An Bord Pleanála Oral Hearing

Case reference: PL06F.301908

Submission by

Sabrina Joyce-Kemper

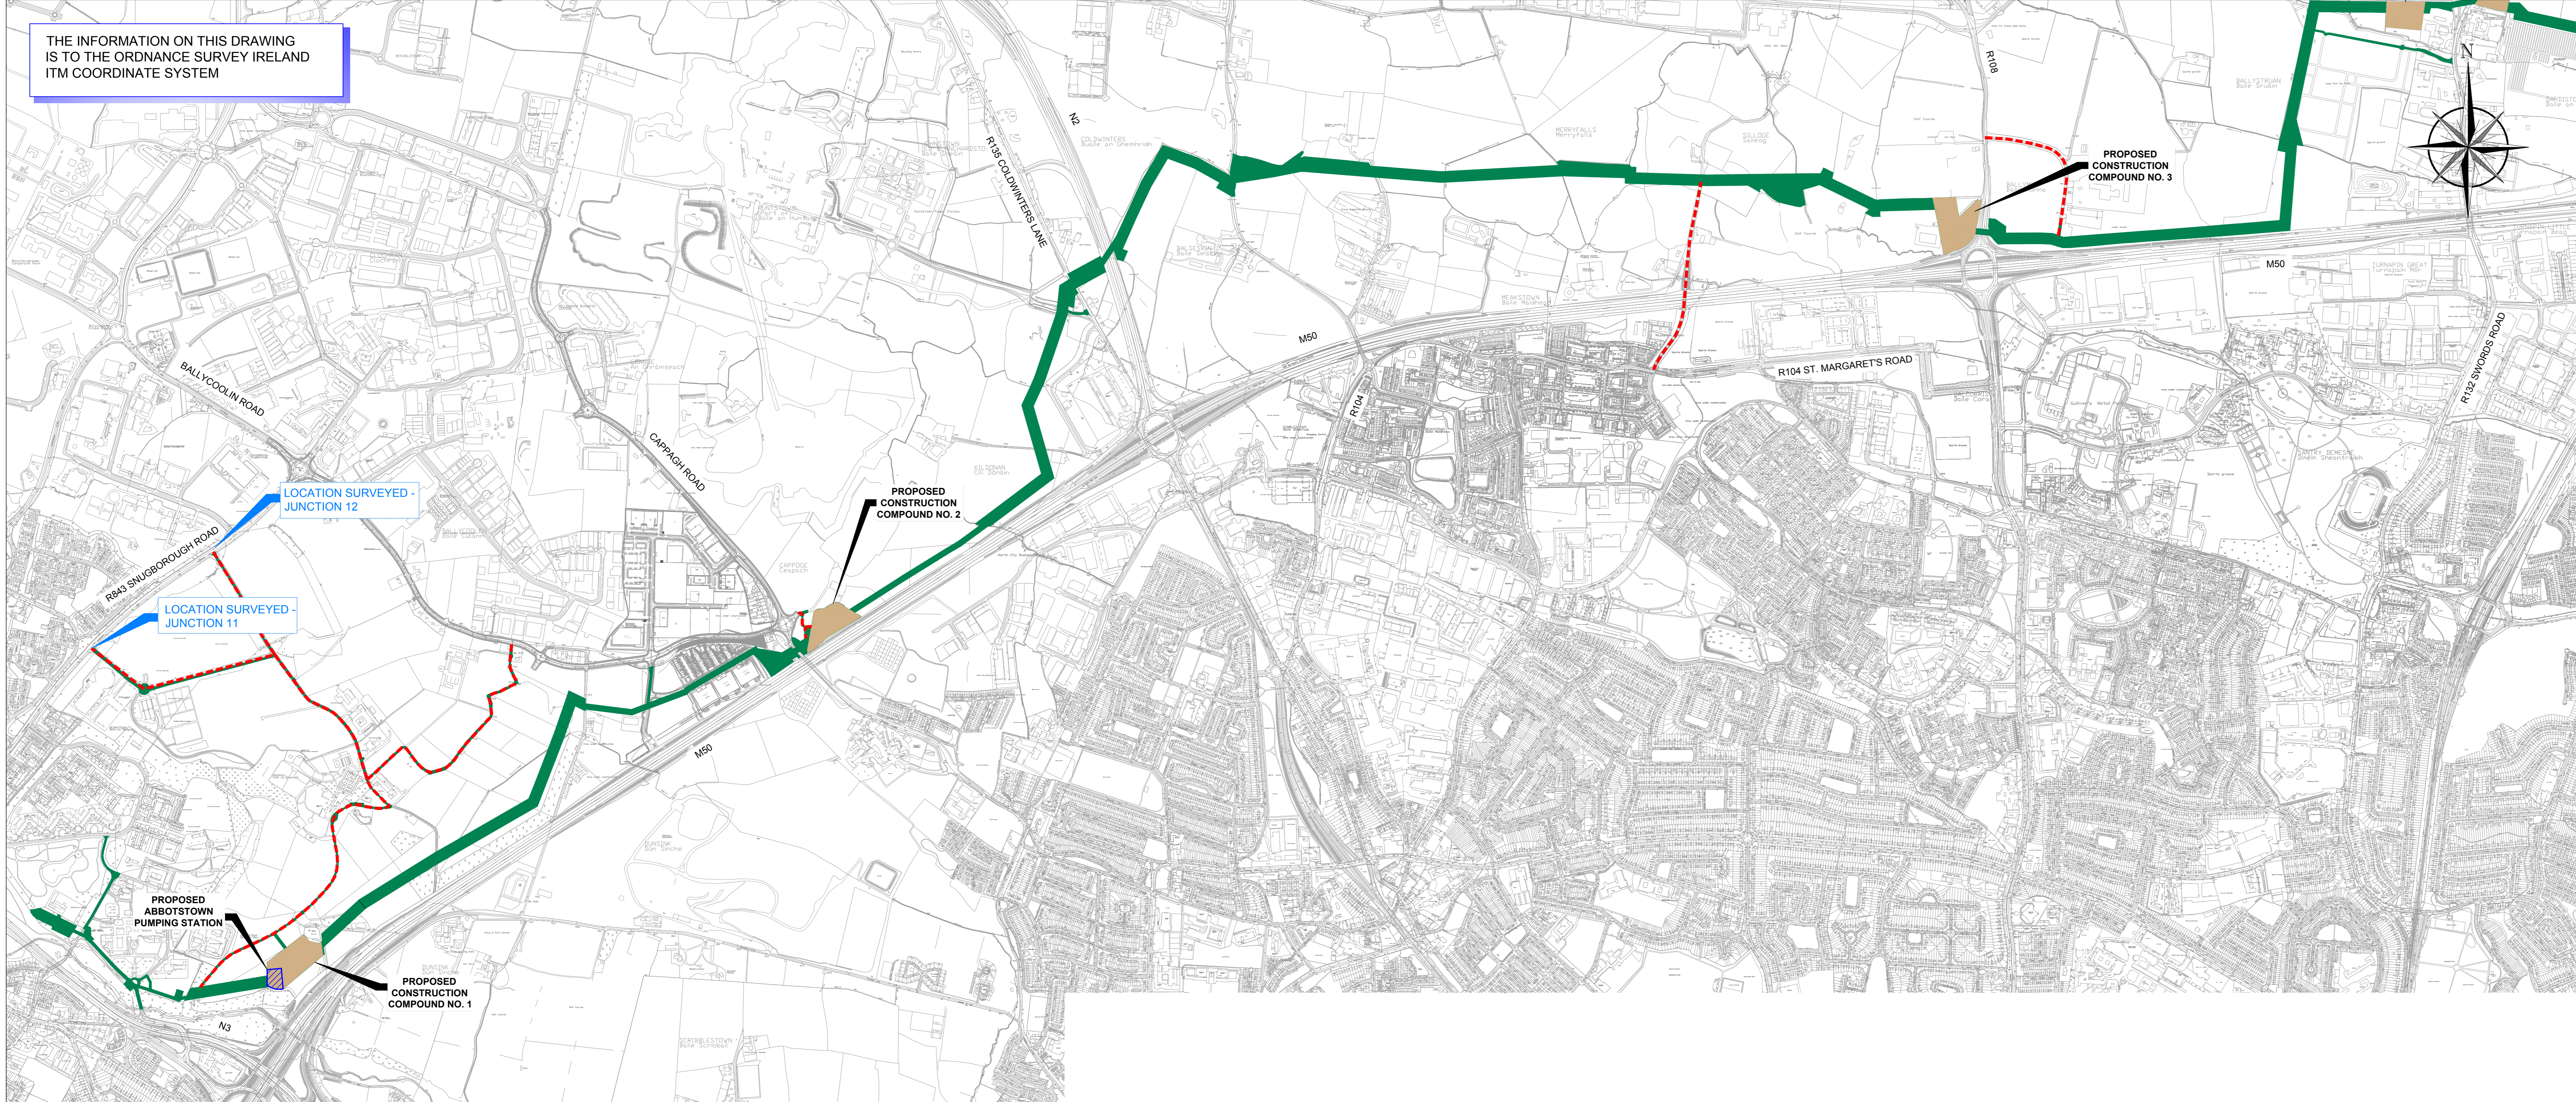
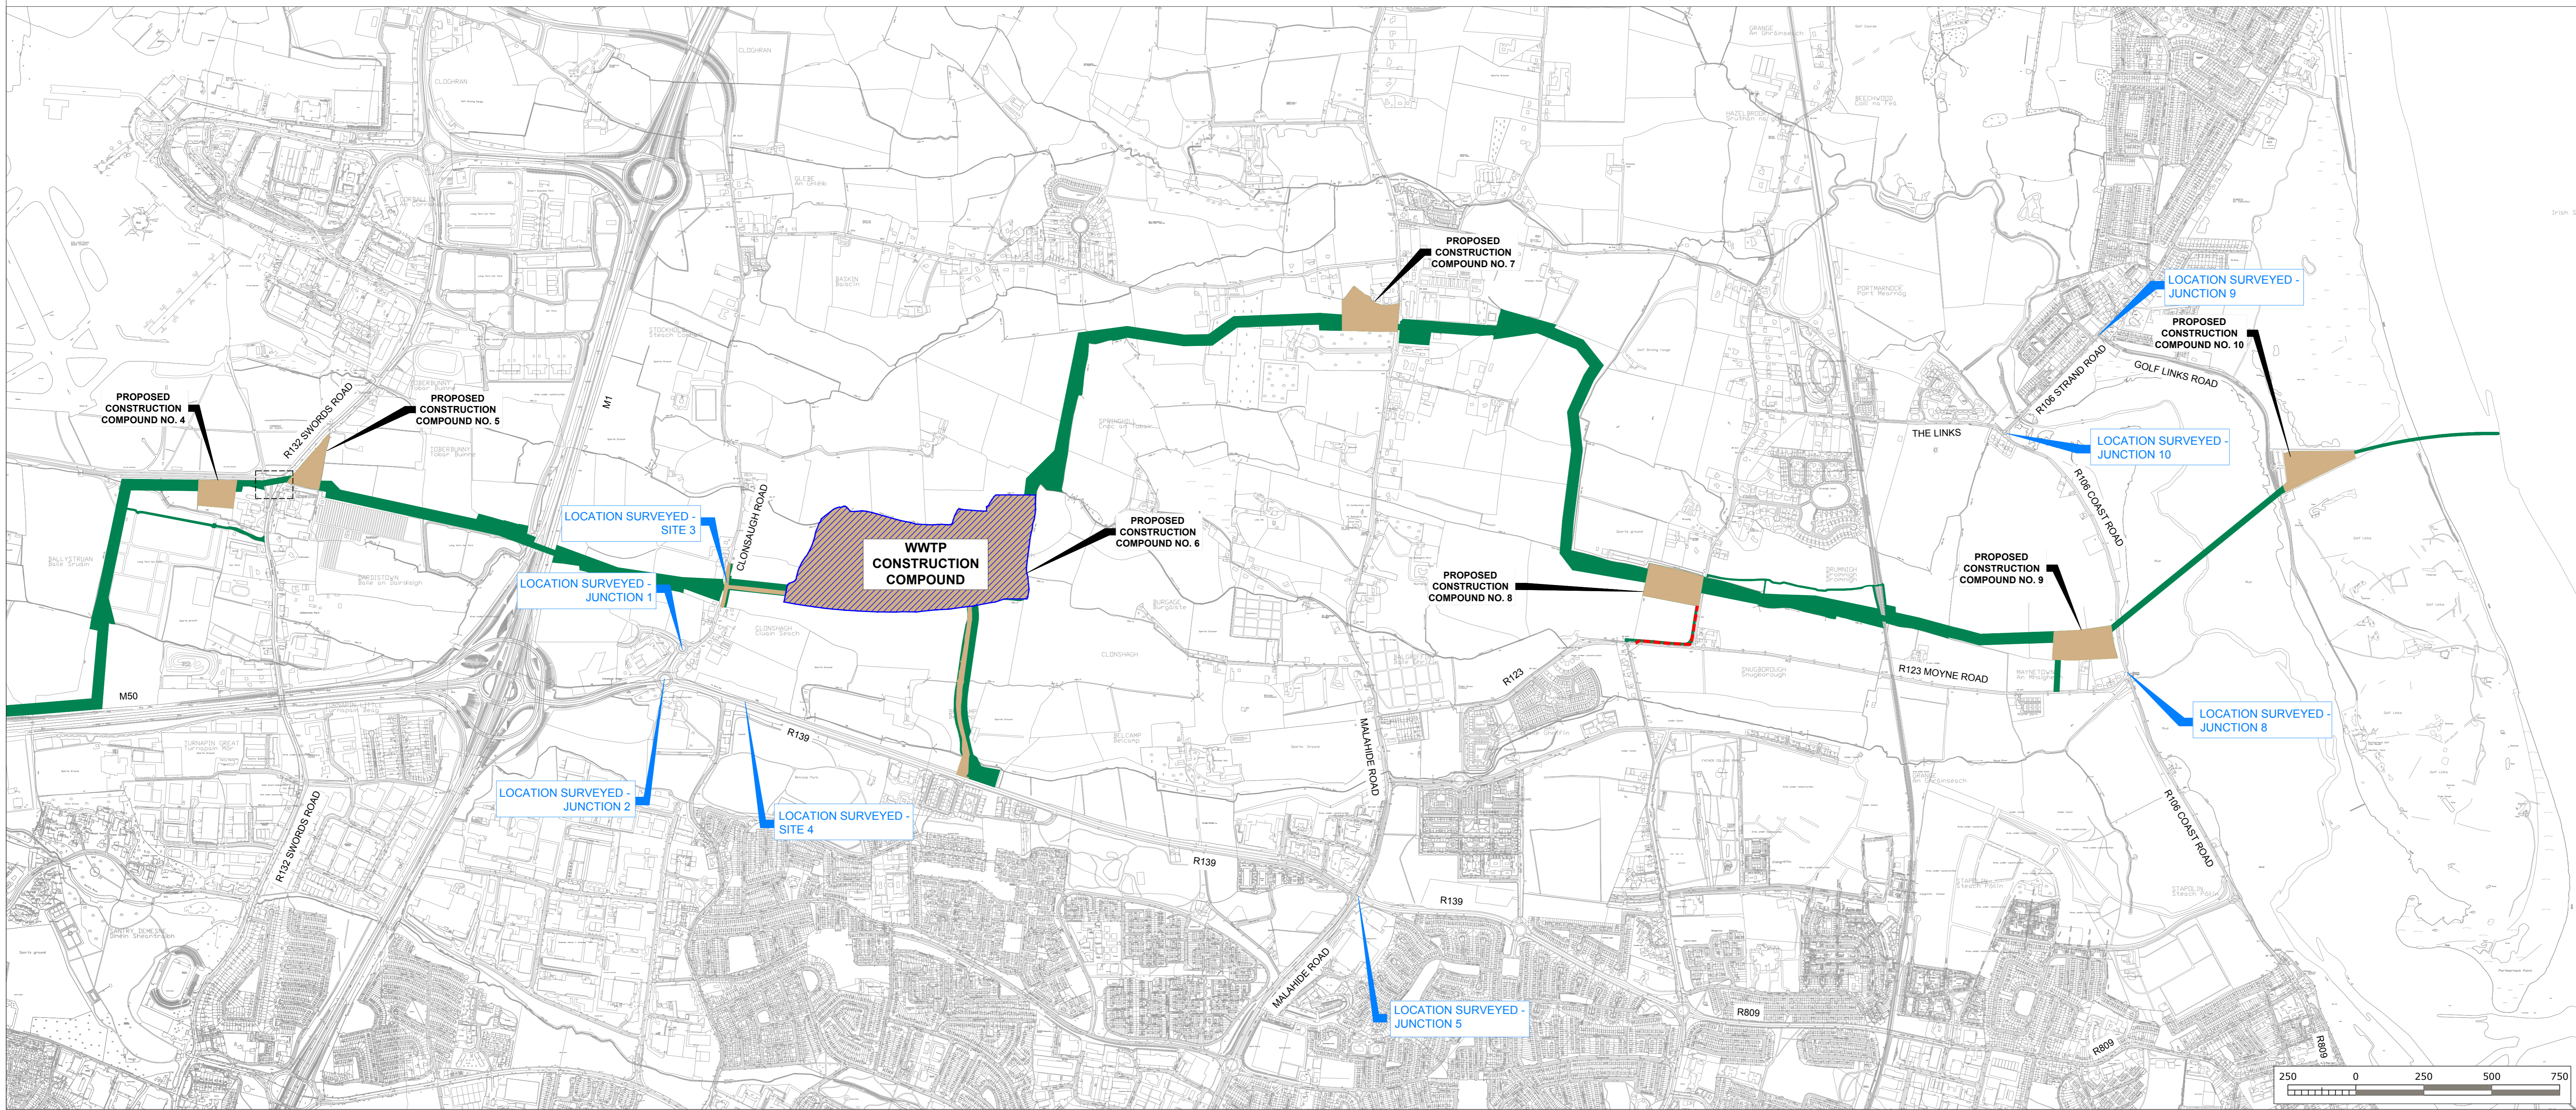
16. The EIAR traffic assessment does not mention and therefore mitigate against, the danger to pedestrians and wildlife on the Golf links road approach to the construction compound 10 entrance. The road is extremely narrow with raised bank along part of the road; there is no pedestrian path on either side of the road. (Figure 3) It is an access road for one housing estate, at which point the majority of vehicles turn off the road. The remaining stretch of road gives access to the Golf club and a beach car park and has minimal traffic movements. Two cars can barely pass each other at some sections of the road. A HGV truck and car may have great difficulty doing so.

17. The turning circle required to access and egress the entrance to compound 10 with a HGV would not be accommodated by the current road layout and no alternative layout has been proposed or tracking of the turn diagrammed. The traffic movement chart (Figure 4) Shows the incredibly high number of car and HGV movements down this road. It is a local walking route and many pedestrians walk here in family groups, with children on scooters, and with their dogs. There is a very real risk of injury to walkers due to the high HGV movements and the valley effect with nowhere to step off the road safely to avoid construction traffic and loads. This road surface would also suffer from so many fully laden HGV vehicles carrying constructional materials and plant equipment onto the site.
